A303 Sparkford to Ilchester Dualling Scheme TR010036

8.8 Draft Statement of Common Ground with Defence Infrastructure Organisation

DRAFT STATEMENT OF COMMON GROUND

Drawing Title: **CROWN LAND PLAN REGULATION 5(2)(n) SHEET 1 OF 1**

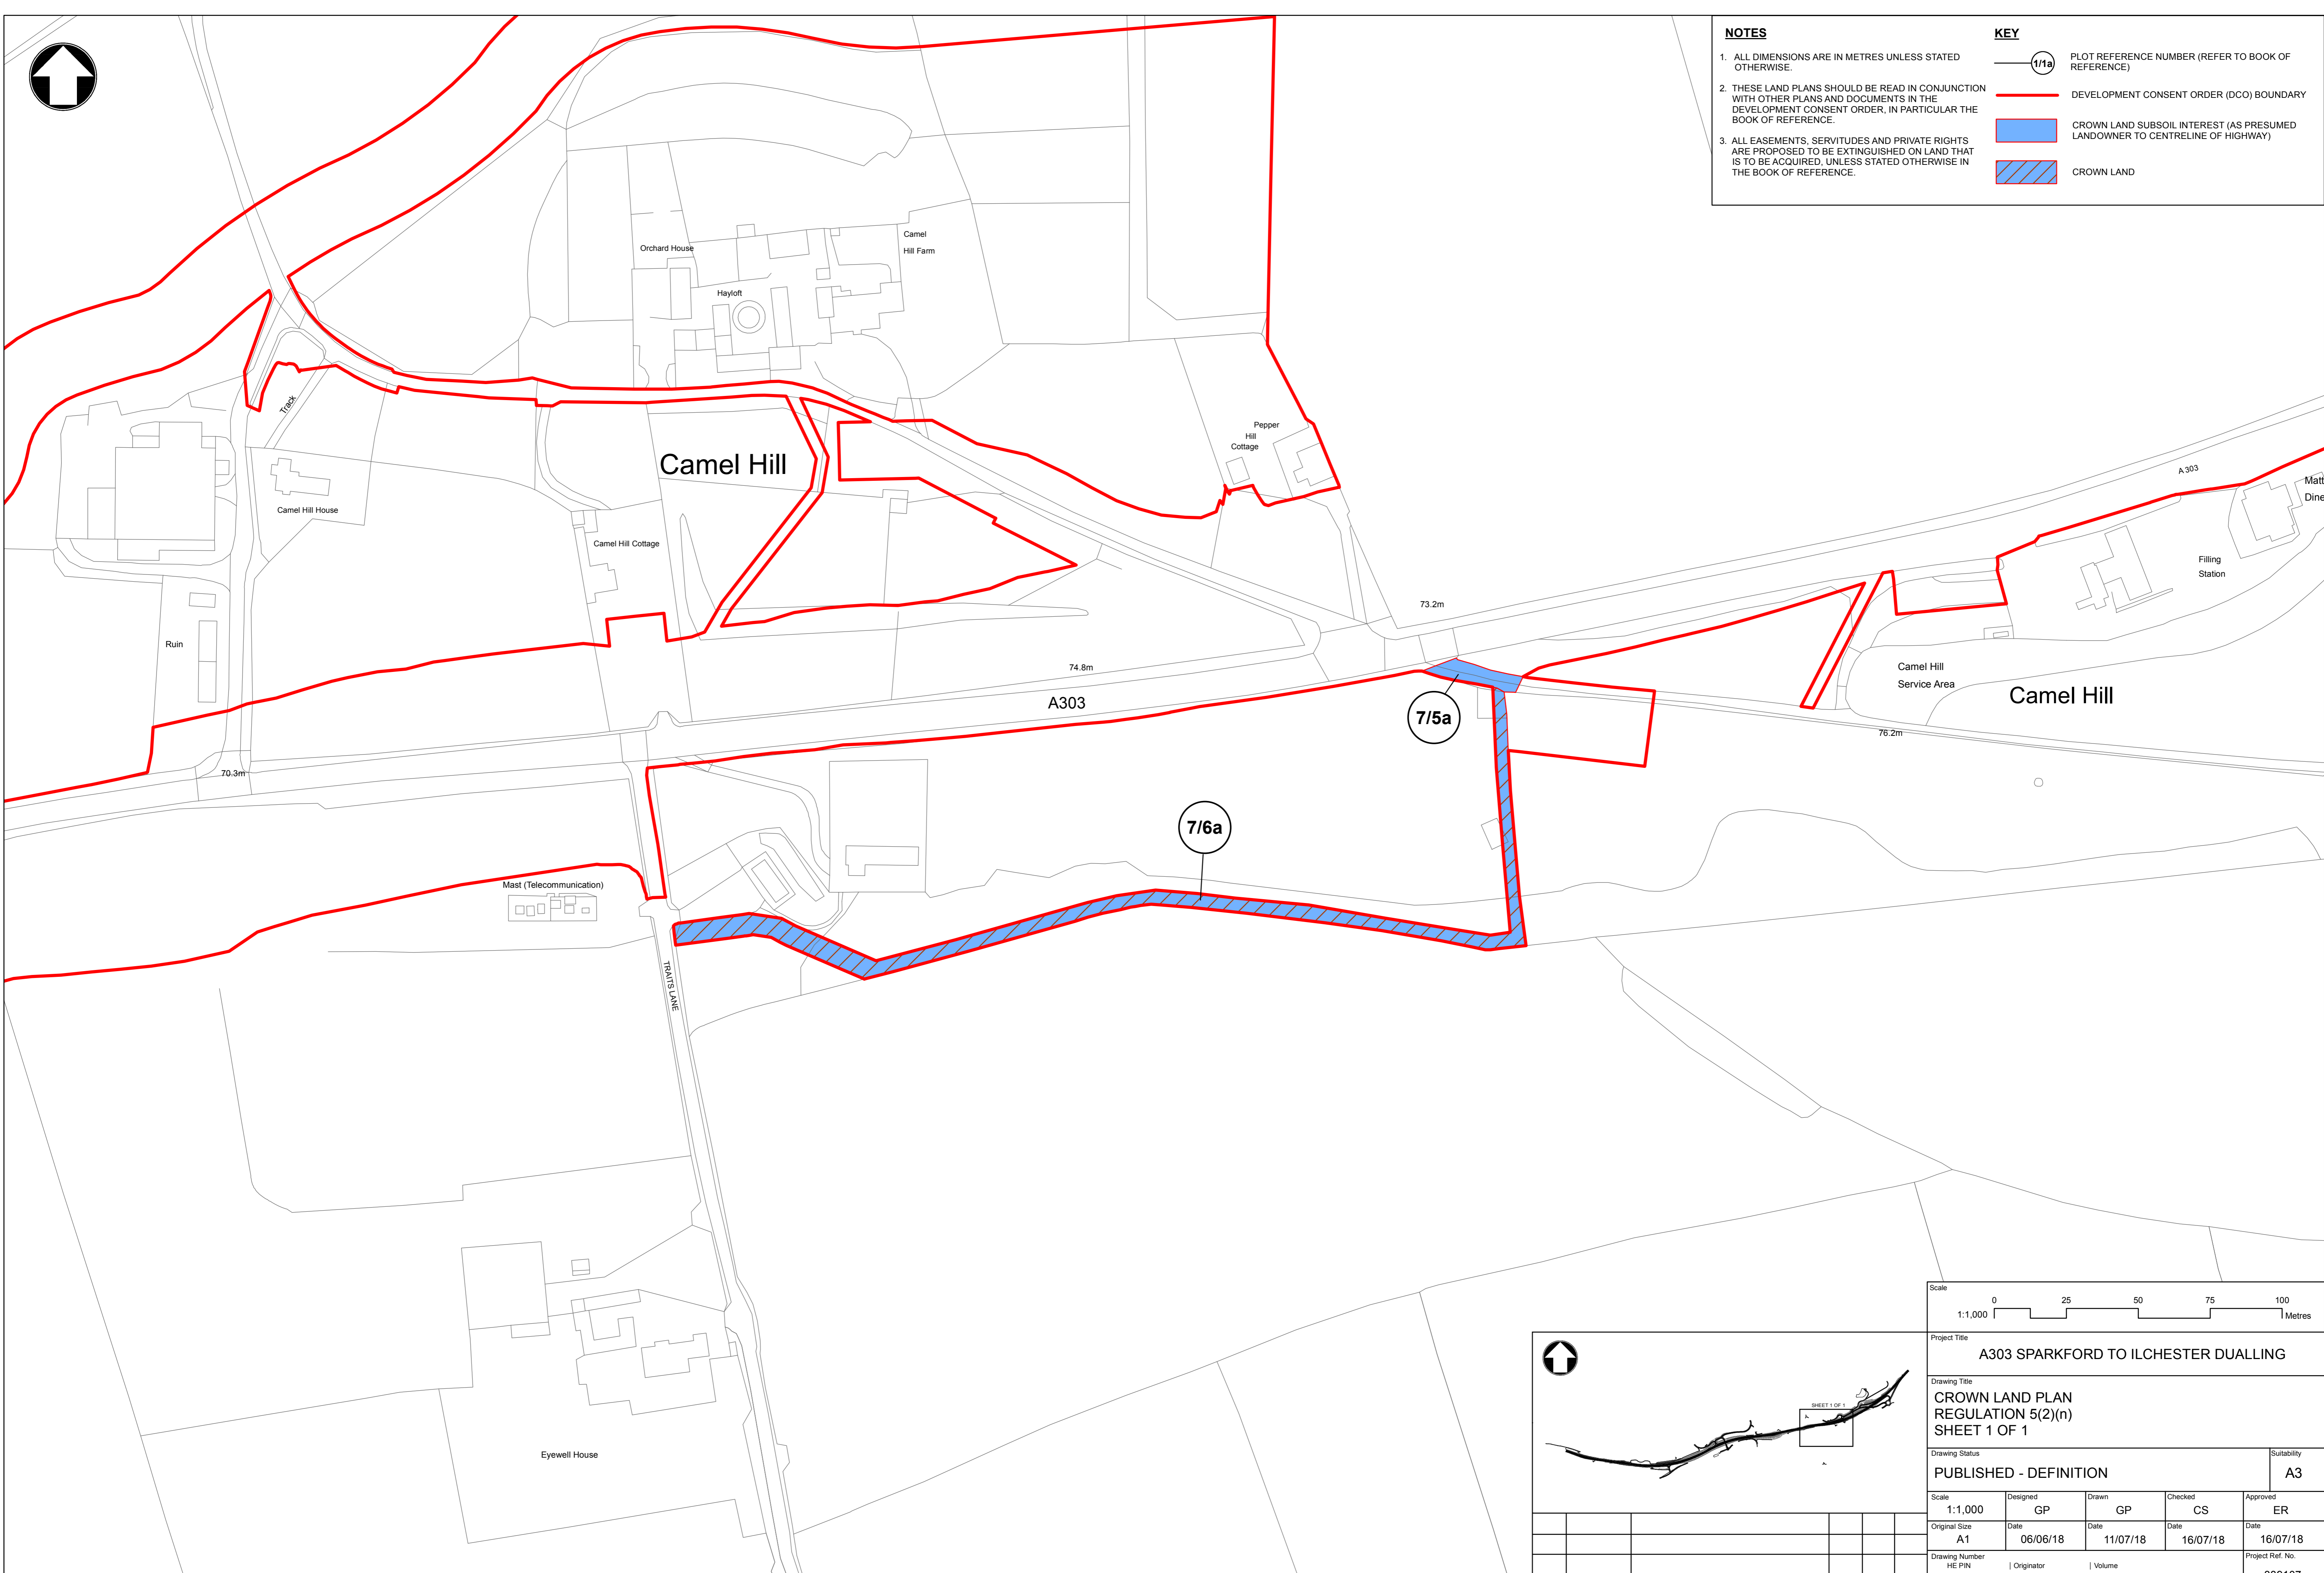
Topic	Sub-section	Defence Infrastructure comment	Highways England response	Status
		limitation surface maximum height analysis and determined we would have no safeguarding concerns subject to the development east of 356140,124638 and 356132,124860 being no higher than 9m above ground level. DIO Safeguarding has no concerns regarding development of up to maximum height 18m west of this location.	Highways England has attached a drawing to this SoCG showing these height restrictions.	
Bridleways	Bridleway proposed across land owned by Secretary of State for Defence at Camel Hill.	We are content with a footpath diversion across the MOD land as shown on the proposed plan; however, this will be on the basis that we will not be responsible for the construction or upkeep of the footpath. We would also like to see a fence line to be installed to make the route through the wood irrefutable. We are not content with a bridleway diversion.	Highways England acknowledges that the MOD and DIO will only accept a proposed footpath and not a bridleway. Formal agreements have been drawn up for review by both the DIO and Somerset County Council. Letter of consent received from the MOD for the acquisition of plots 7/5a and 7/6a.	AGREED
